30 April 2018

Please find our response to the SSD 8372 'Response to Submissions (RtS) Report prepared by RPS and Congrad Gargett for the Smalls Road Public School, Ryde, Development Application.

The RtS report addresses many of the recommendations of the GANSW Design Review Report dated 16 December 2017, however some documentation remains outstanding.

DRAWING
Sections

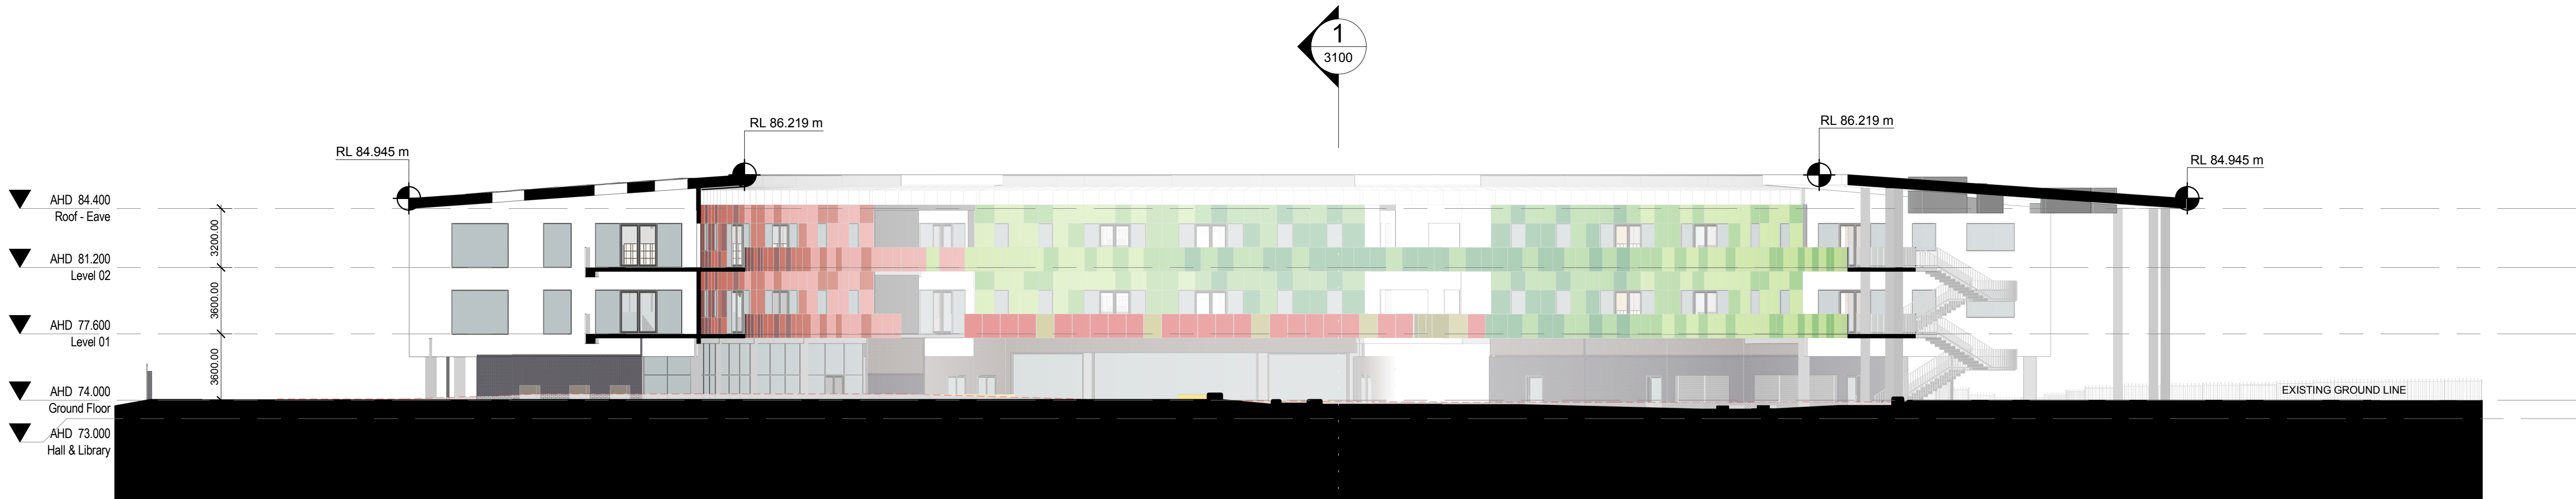
- *A physical material samples board (no larger than A3) with correct proportional representation of internal and external materials*
 - Provided and accepted.
- *Detailed annotated wall sections at 1:20 scale that demonstrate typical cladding, window and door details, including materials and general construction quality.*
 - This has not been provided.

Suggested condition: provide 1:20 typical sections indicating the above for GANSW review and endorsement

1 North East Elevation
2100 1:200

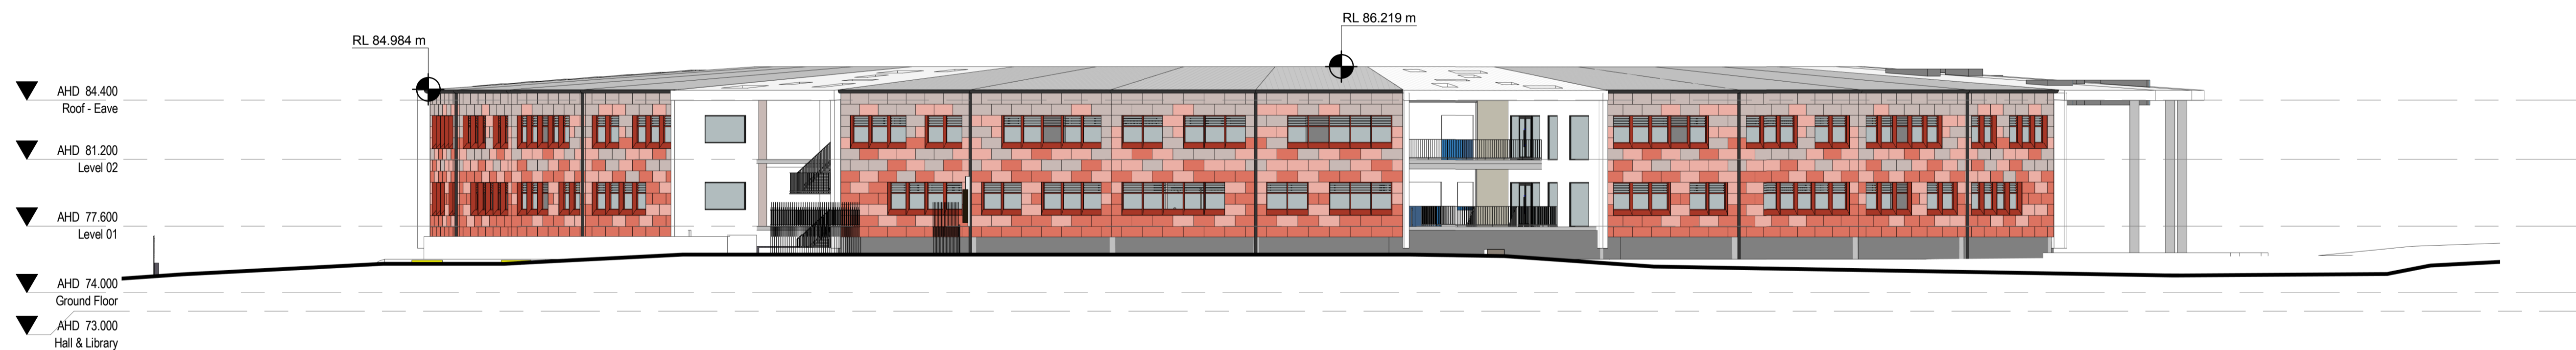
- *Review the design approach to the building elevations to more appropriately reflect the boldness and playfulness of the plan diagram.*
 - RtS report notes that the elevations will be further developed in future “detailing and documentation stages”,

Suggested condition: submit revised elevations at 1:100 indicating the design development of the façade for GANSW review and endorsement.
